Our Ref: A/91/22/DOC

Town & Country Planning Act 1990 (as amended)
Town and Country Planning (Development Management Procedure) (England) Order 2015
Approval of details reserved by condition imposed under A/40/18/OUT relating to condition 41-access
works to Water Lane.
Land North of Water Lane and South of A27 Angmering BN16 4EU

Arun District Council have decided to **REFUSE details reserved by condition for the following reasons:**

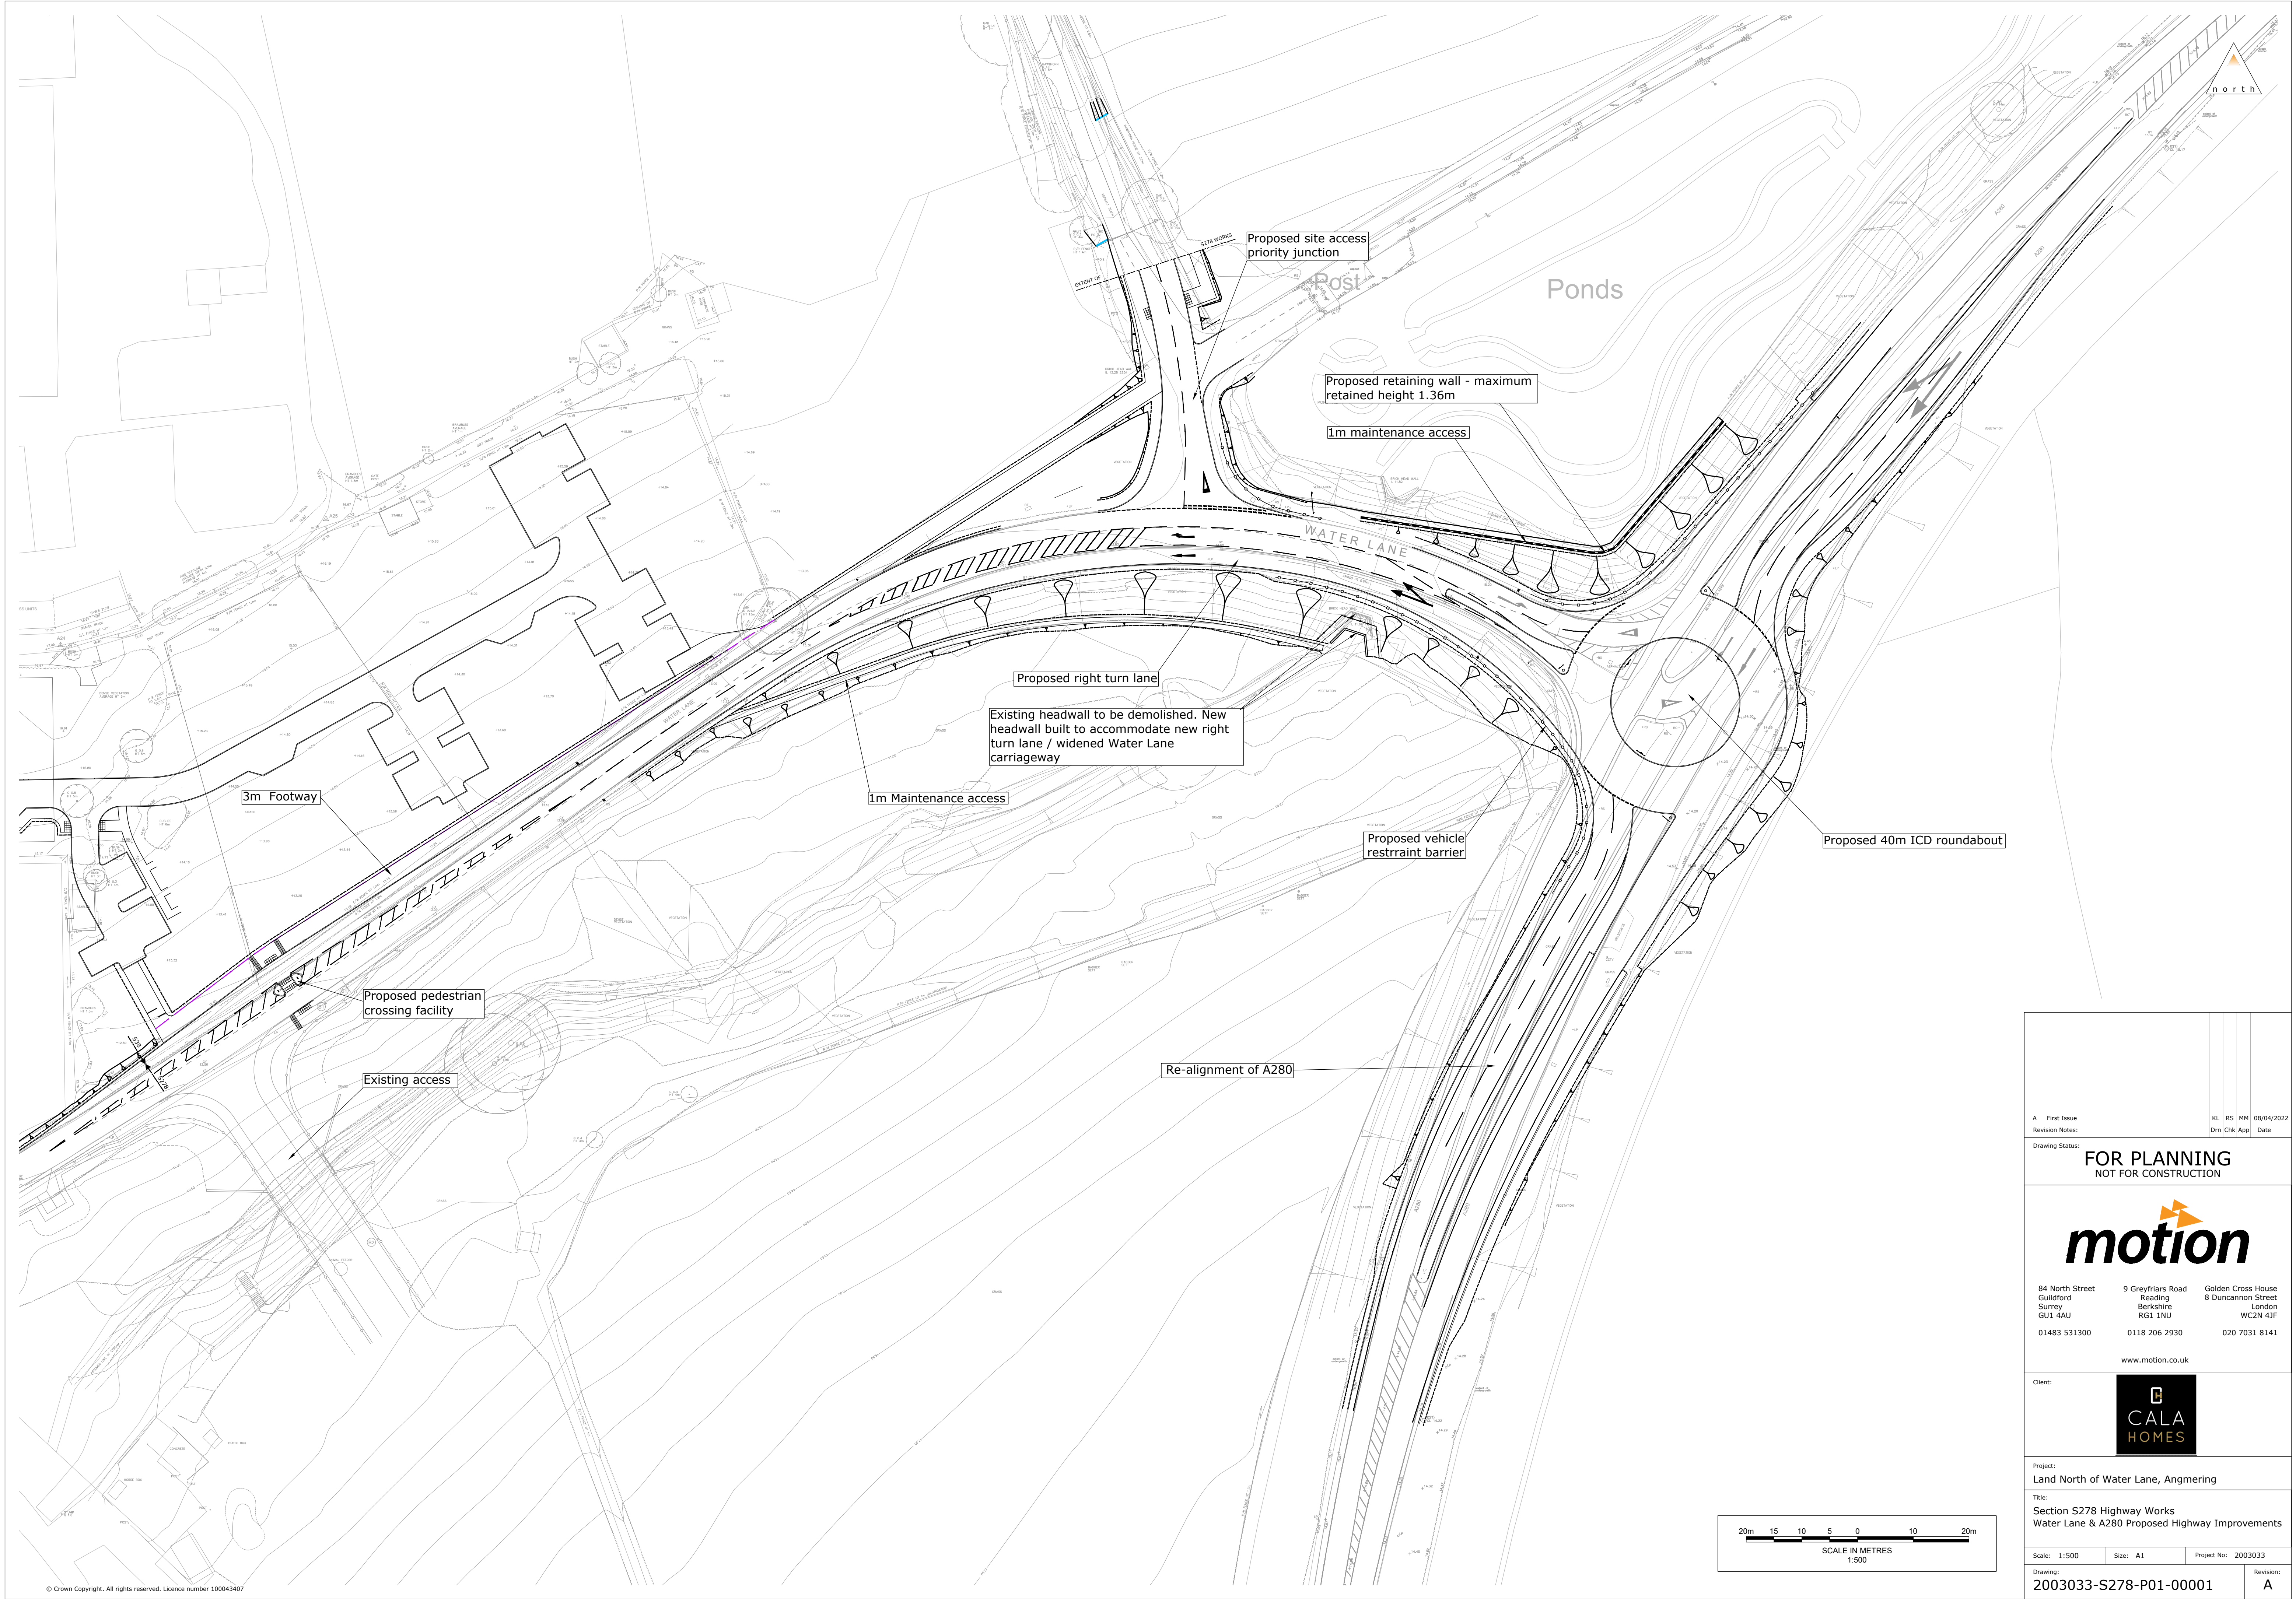
Insufficient detail has been submitted in order to discharge the condition. WSCC have requested amendments to the scheme, including confirmation that the 3m wide footway along Water Lane is a shared use route and the type of pedestrian/highway barrier required. Therefore, the condition cannot be discharged at this time.
